Appeal Decision

Appeal Ref: APP/Z4718/D/23/3330175

690 Bradford Road, Fixby, Huddersfield HD2 2JY

- The appeal is made under section 78 of the Town and Country Planning Act 1990 against a refusal to grant planning permission.
 - The appeal is made by Mr Harbinder Johal against the decision of Kirklees Metropolitan Borough Council.
 - The application Ref 2023/62/91595/W, dated 30 May 2023, was refused by notice dated 26 July 2023.
 - The development proposed is single storey rear extension, two storey side extension with integral garage.
-

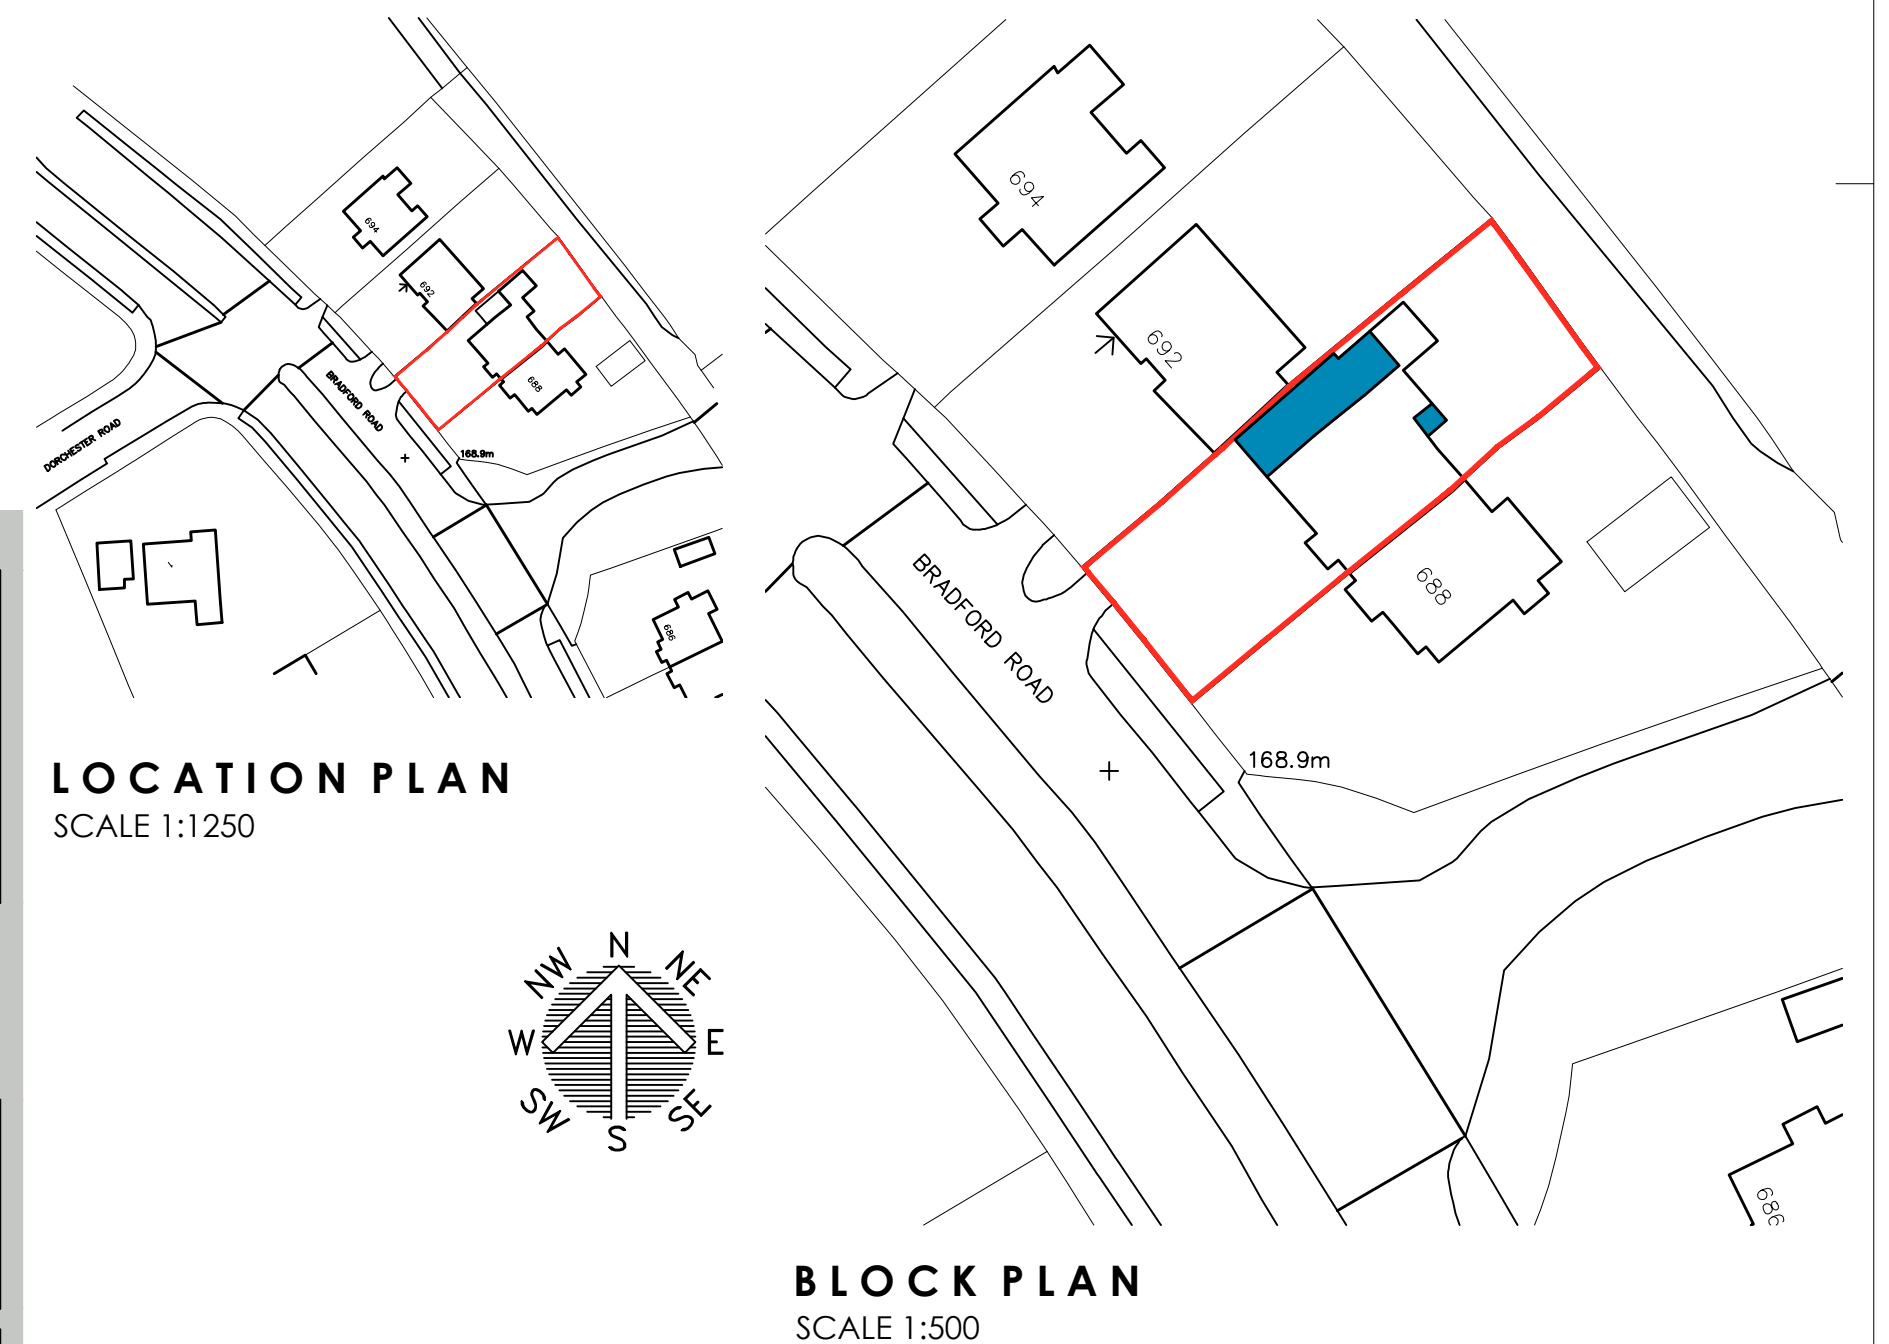
6. The proposed two storey extension would feature a hipped roof and a pitched gable to the front elevation, which would broadly reflect the character of the existing building, and it would be constructed in sympathetic materials. I also acknowledge that the proposed two storey extension would clearly have a smaller footprint than the existing building. The proposed lean-to canopy would create a visual break between the garage and the first floor to the front elevation of the side extension. Nevertheless, it would not be set back from the front of the dwelling and the extended roof would not be set below the existing ridge. The new projecting front gable would compete with the existing gable features to the front of the property, thereby accentuating the substantial bulk and massing of the proposal. As a result, the proposal would fail to achieve a subservient relationship to the host property.

7. Moreover, the combination of the length and width of the two storey extension, its proximity to the boundary with No 692, and the lack of a set back, would result in a cramped appearance and an unacceptable loss of openness between the two properties at first floor and roof level. Consequently, the proposal would not respect the spacious characteristics of the area. Although the property is set back from Bradford Road, the proposal would still be clearly visible in views along the road. Whilst I acknowledge that the site is not within a conservation area, the proposal would nevertheless be an overly dominant addition to the property to the detriment of the street scene.
